15 October 2012

**STATEMENT OF ENVIRONMENTAL EFFECTS: SECTION 75W APPLICATION TO MAJOR PROJECT APPLICATION NO. 10\_0177 AT 14-18 BOONDAH ROAD, WARRIEWOOD (LOT 20, DP 1080979) TO VARY CONDITION A1 RE: BUILDINGS F, G & POOL**

SUMMARY OF CHANGES

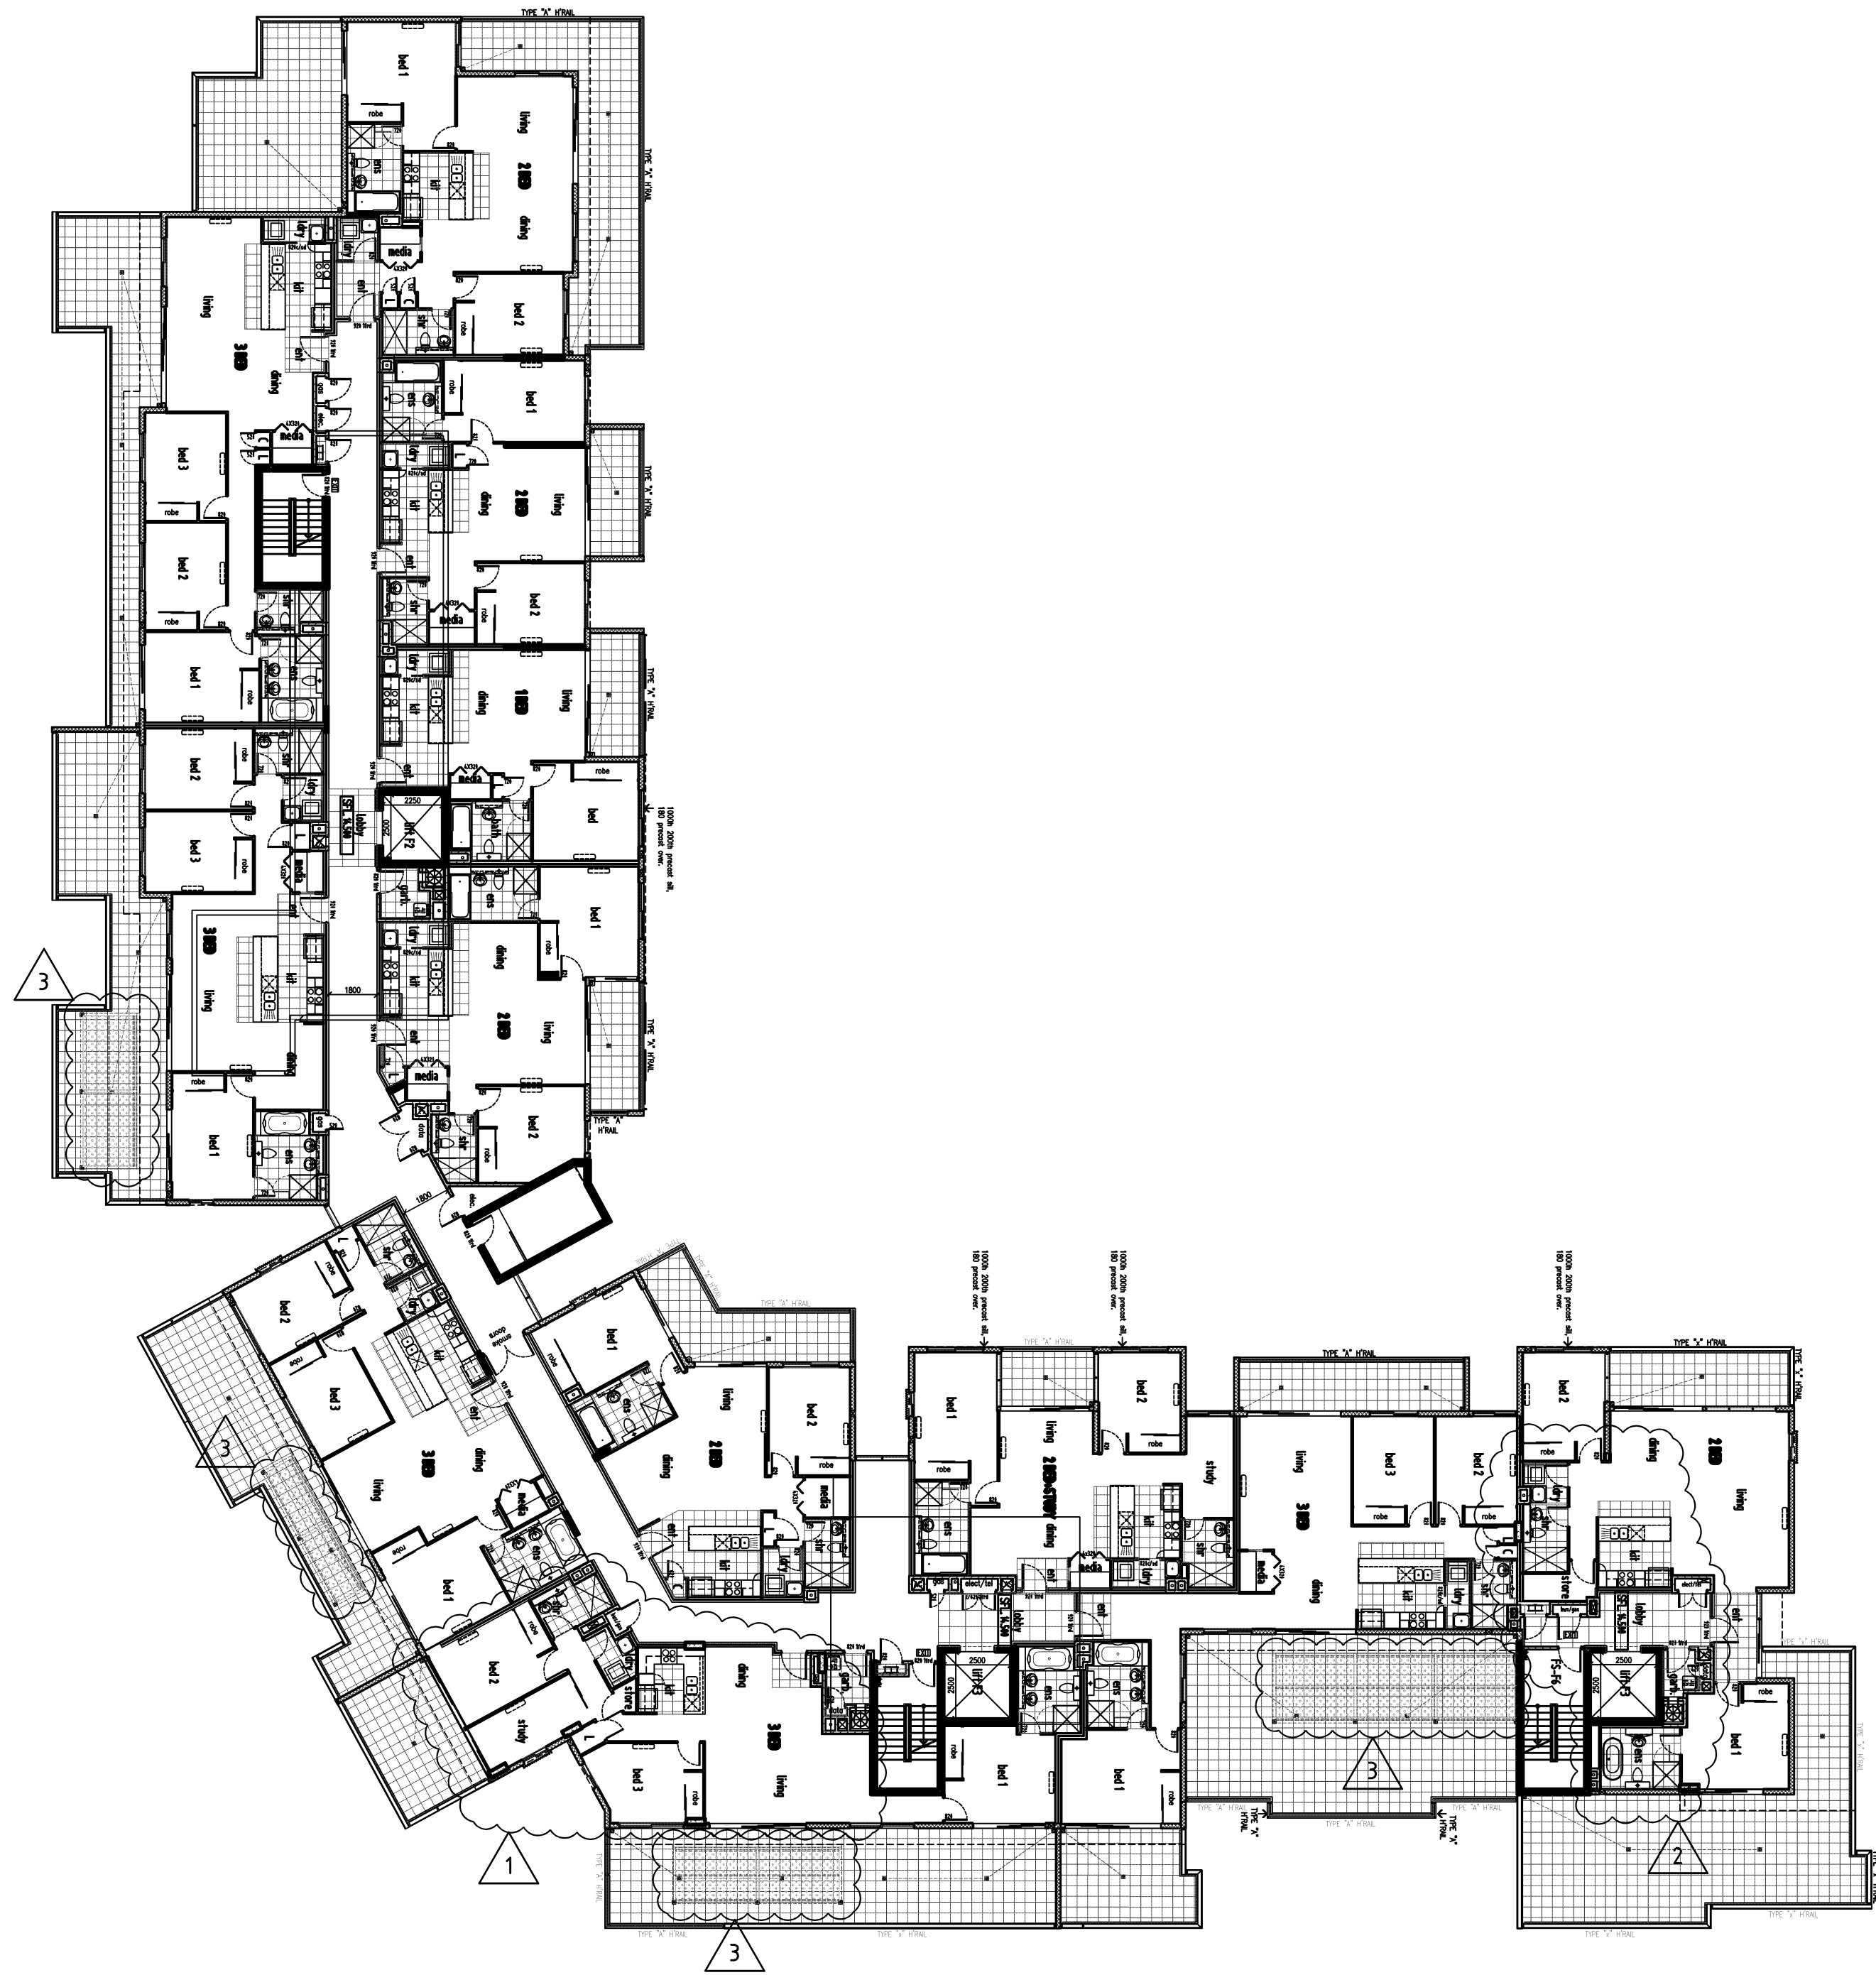
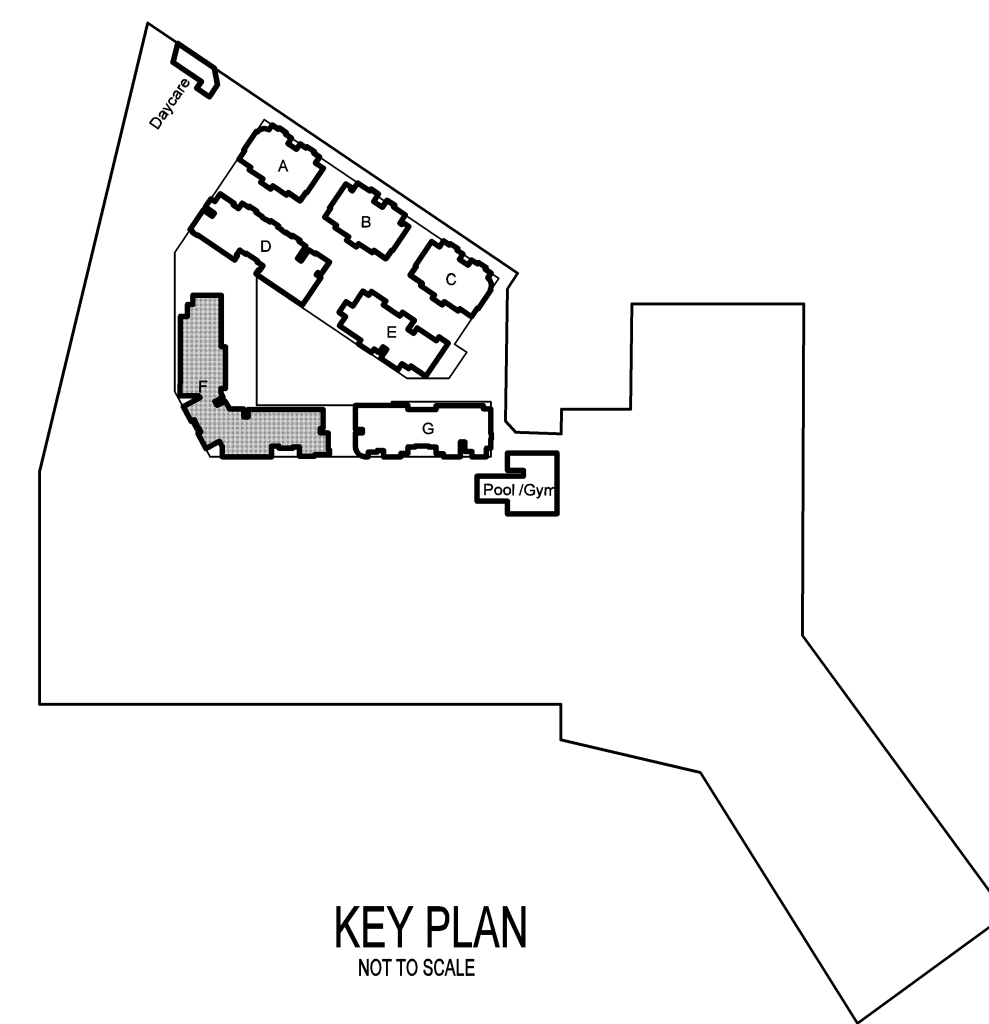
The layout of Unit 349, within Building F has been reconfigured to allow for an additional study area. The proposed study is located between bedrooms 2 and 3. This will create privacy and provide an additional working space. Similar design modifications were successfully introduced into other Buildings within the same project, and have been very positively received by purchasers. Refer to proposed plan DA 26, point 1 for the reconfiguration of Unit 349.

The layout and foyer area of Unit 354 within Building F has been improved to provide a more useable and functional space. Refer to proposed plan DA 26, point 2.

Pergolas have been added to Units 347, 349, 350 and 353 in Building F to provide shade from the sun, and reduce the impact of rain into the terraces. The introduction of pergolas also adds architectural interest to the building. Refer to proposed plan DA 26, point 3 for the location of the above mentioned units.

The roof level slab has been extended to provide a cover to the terraces below to improve shelter from weather conditions on Building F. Refer to the Roof Plan on proposed plan DA 26, point 4 for the location of the roof overhangs. The roof level slab has also been extended on the north western corner of Building G to similarly improve shelter from weather conditions. Refer to proposed plan DA 28, Roof Level plan, West Elevation and point 2 for the location.

A portion of the roof has been raised, situated above specific balconies on the northern elevation of Building F. This will provide protection from various weather conditions and provide visual interest to the building. Refer to proposed plan DA 26, point 5.

FLOOR PLAN
POOL and GYM

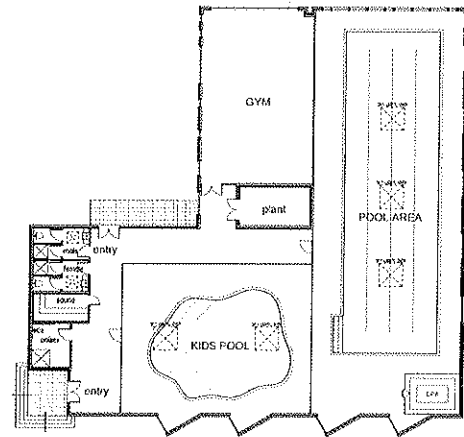
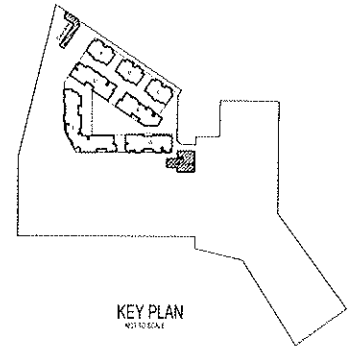
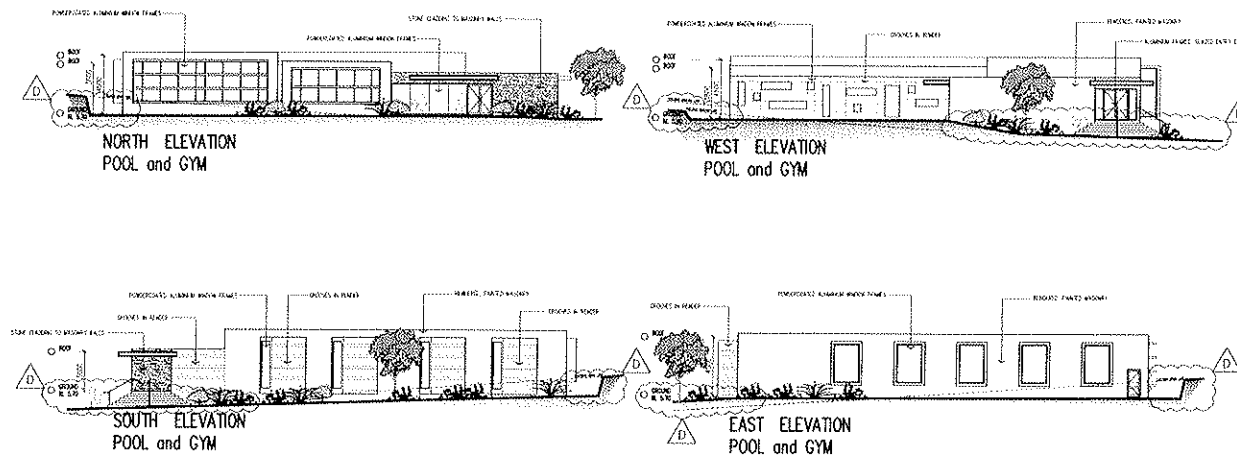
The height and head height of windows on the East Elevation of the swimming pool are to be reduced. Refer to East Elevation on proposed Plan DA30, Point 1.

The heights of window bays on the South Elevation of the swimming pool have also been increased to allow more natural light into the building. Refer to East Elevation and South Elevation on proposed Plan DA30, Point 2.

The shape of the Children's pool has been reconfigured as the original had difficulties in terms of construction. Refer to Floor Plan, Pool and Gym on proposed Plan DA30, Point 3.

The location of the spa has been revised to allow for a more logical and safer transition between the pool and the spa. Refer to Floor Plan, Pool and Gym on proposed Plan DA30, Point 4.

The size of the sauna room has been reduced to allow for sufficient space for the changing rooms. Refer to Floor Plan, Pool and Gym on proposed Plan DA30, Point 5.

A new plant area has been added to the roof. This detail was not previously included in submitted plans of the swimming pool. Refer to North and West Elevation Plans on proposed Plan DA30, Point 6.

The glazing on the doors to the entry of the pool building has been changed to allow for greater privacy and visual interest. Refer to North and West Elevation Plans on proposed Plan DA30, Point 7.

A new column has been added to the south west corner of the building for structural support. Refer to South Elevation Plans and Floor Plan on proposed Plan DA30, Point 8.

An additional skylight has been added to the roof of the pool building resulting in 4 skylights, rather than 3, as previously approved. This will allow for more natural light into the pool area and create a more interesting roof. Refer to Floor Plan on proposed Plan DA30, Point 9.
